# One Earth Solar Farm

**Draft** **Final** Statement of Common Ground with West Lindsey District Council

**EN010159/APP/8.4.54**

December 2025

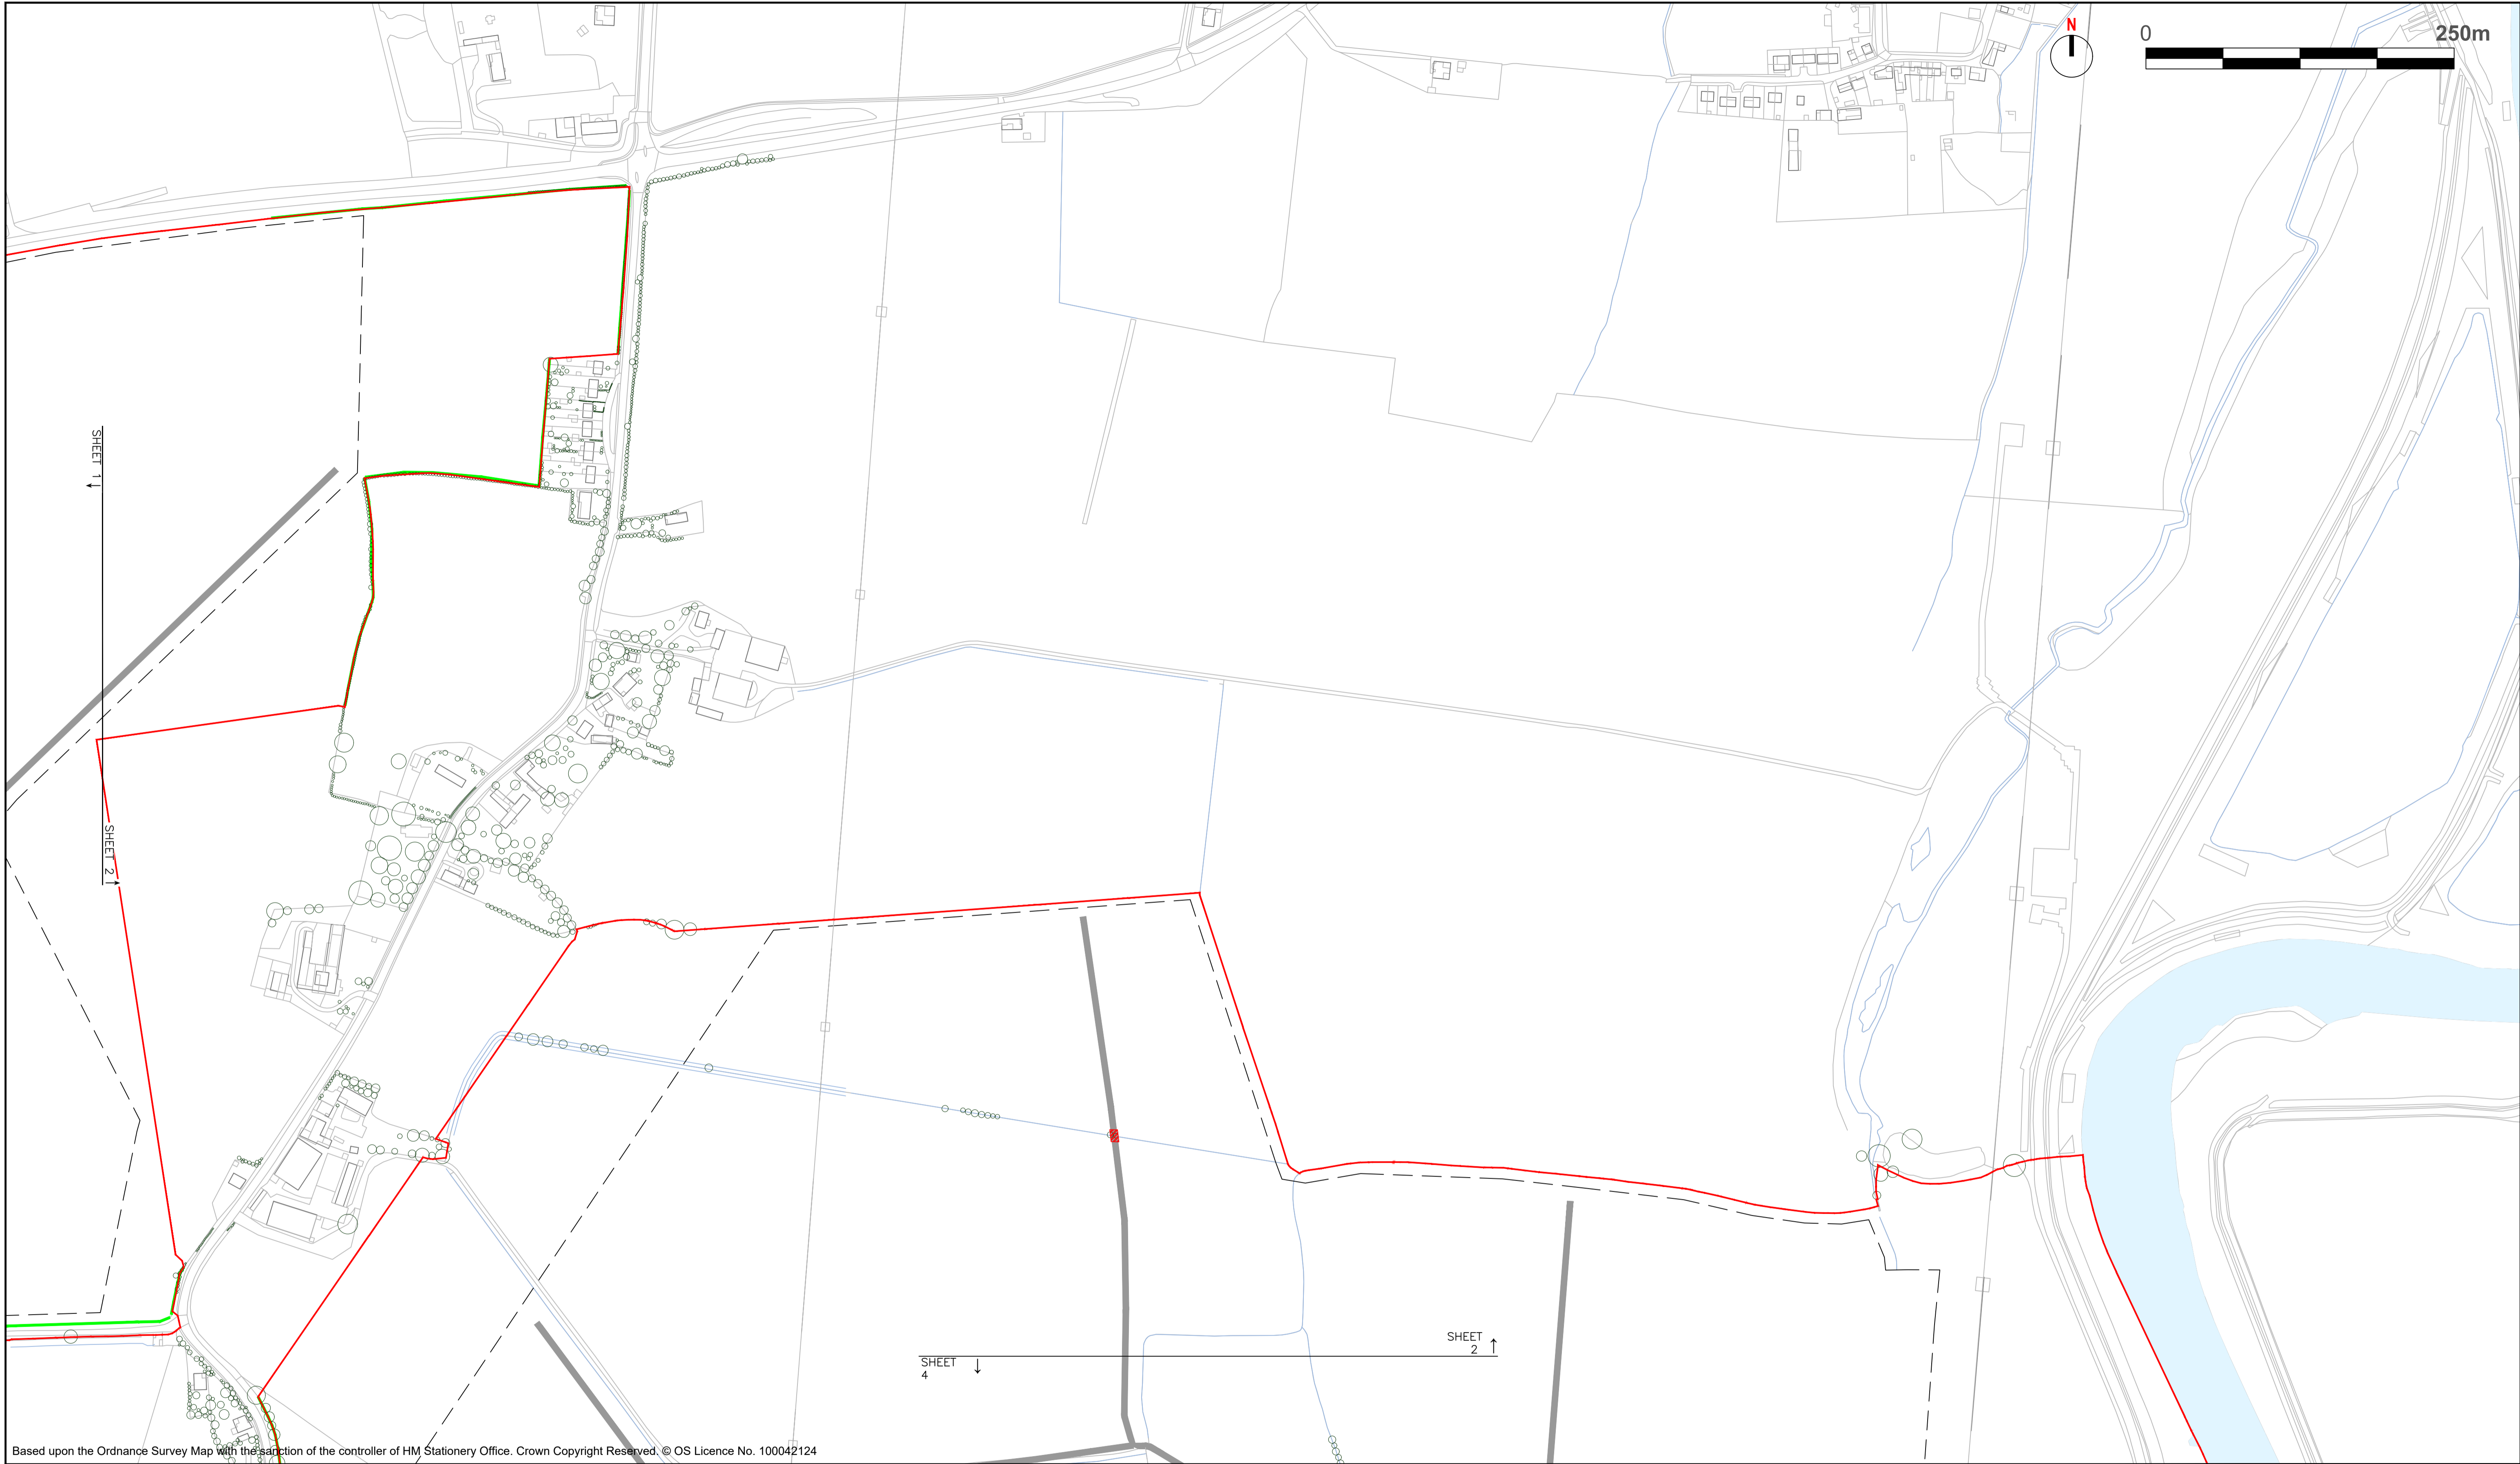
04-11	Vegetation Removal – Gate G	<p>Query around the potential conflicts between the commitments in the oLEMP and what was shown on the vegetation removal plan with regard to access gate G.</p> <p>WLDC await clarity on the interaction between vegetation retention and the use of the existing access north of the reservoir running westwards from Gate G.</p> <p>WLDC has a concern with the landscape effects rather than the transport effects.</p>	<p>The Applicant has agreed in the updated oLEMP at Deadline 5 to secure the retention of the hedgerow north of Gate G in the oLEMP. The following text is has been included in the updated oLEMP at Deadline 5 [REP5-038]-</p> <p><i>“Regarding the hedgerow extending east to west along the northern side of the existing access track located north of the Anglian Water reservoir, west of A1133, the existing hedgerow will be retained. Minor removal will be undertaken as shown on the vegetation removal plan to facilitate the widening of the bell-mouth junction with the A1133, but no wider removal of the hedge is proposed”.</i></p>	Agreed
